**Consultation Response from KC,  
Highways Development Management****2023/92129 Pennine Autos, Wakefield Road, Grange Moor, Huddersfield, WF4 4DS****Erection of single storey extension to rear of existing building****Date Responded: 08/05/24****Responding Officer: CNB****Responding Ref: K16-1/2**

Site Plan
1 : 500

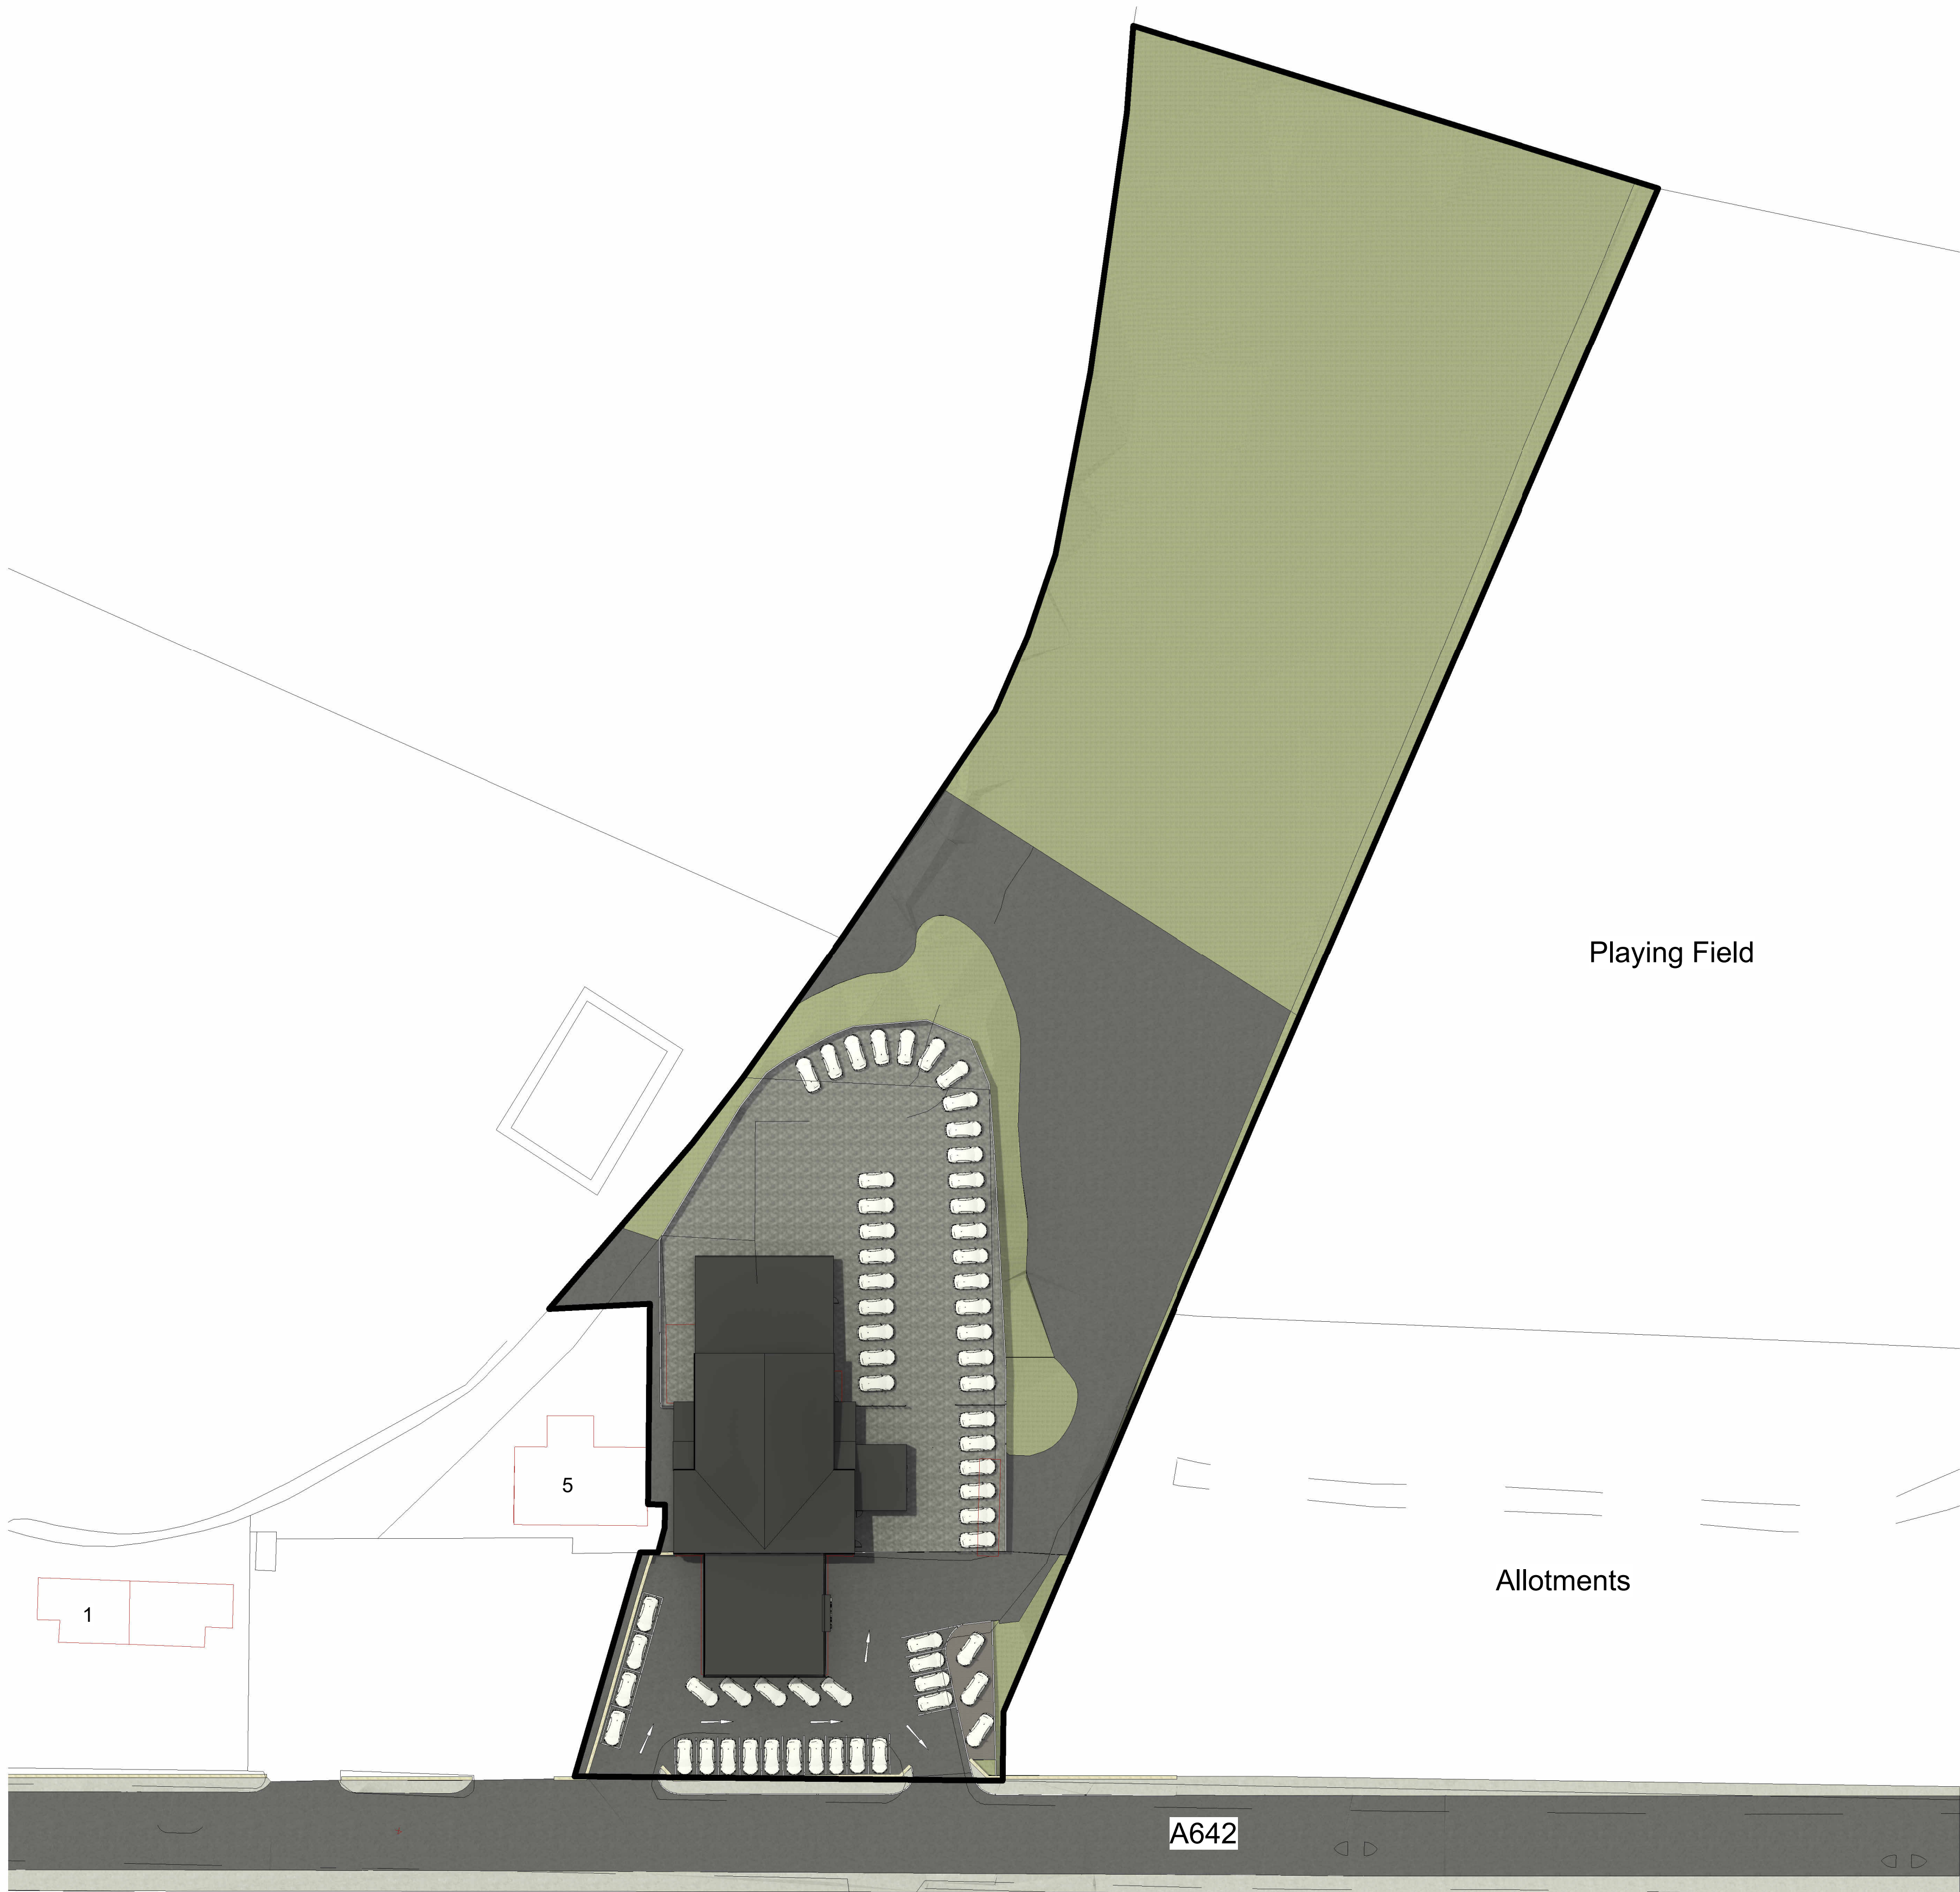
The access into the site is existing and is currently set up as a one-way circulatory system with the eastern access marked as the entrance and the western access marked as the exit, although it is noted that there are right turn lane markings in to both accesses. It is noted that on drawing No (100) 07 (3D Massing as Proposed) indicates that the one-way system is to be reversed, however no other layout drawings have been provided to show this layout.

There are no drawings submitted with the application that clearly show the layout of the revised access and the parking layout, this would need providing prior to commencement of the development and can be conditioned as we feel there is sufficient space within the site to provide for the parking and revised access.

Notwithstanding the details shown on the approved plan, no development shall take place until a scheme detailing arrangements and specification for layout of parking and deliveries have been submitted to and approved in writing by the Local Planning Authority. Before any building is occupied the development shall be completed in accordance with the details shown on the approved plans and retained thereafter.
